Your reference :
Our reference : SF14/6738; DOC16/602437-04
Contact : Mr Allan Adams; (02) 6332 7610

13 December 2016

I refer to your request by email to the Environment Protection Authority (EPA) on the 28 November 2016 for comments and recommendations on the Western Coal Services SSD 5579 Modification 1 (MOD1).

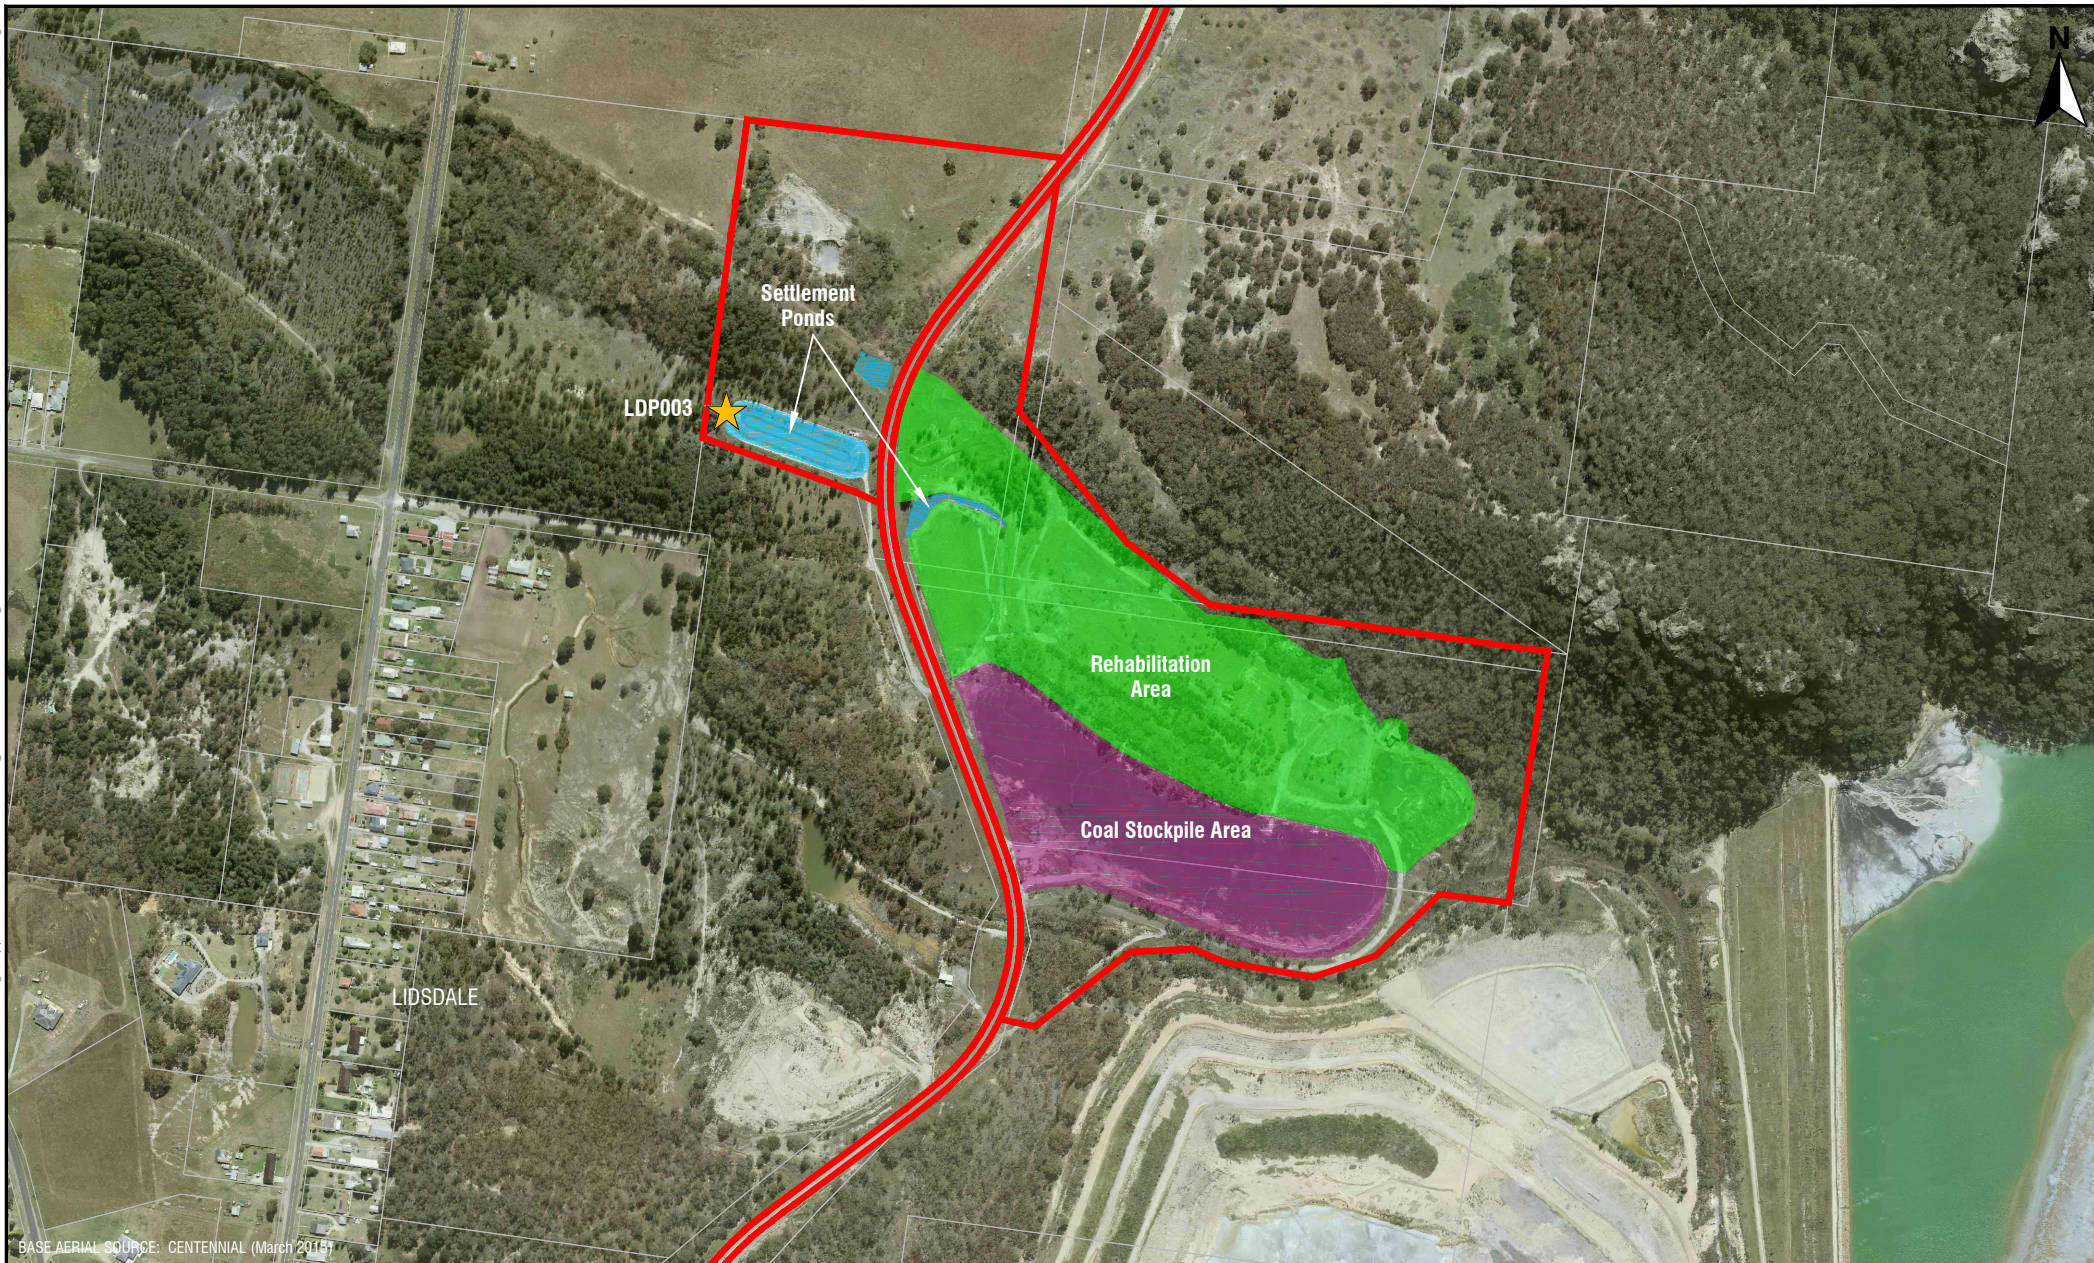
In addition, the EPA is seeking clarification on the exact location proposed for disposal of the residuals. Figure 5 of the main report titled '*Springvale Coal Services Site Infrastructure*' shows the Co-disposal REA located near the main entrance on the eastern side of the site. Whereas, Figure 11 of the main report titled '*Residuals Transfer Pipeline at Springvale Coal Services Site*' shows the Residuals Transfer Pipeline terminating at the REA located on the southern boundary of the site.
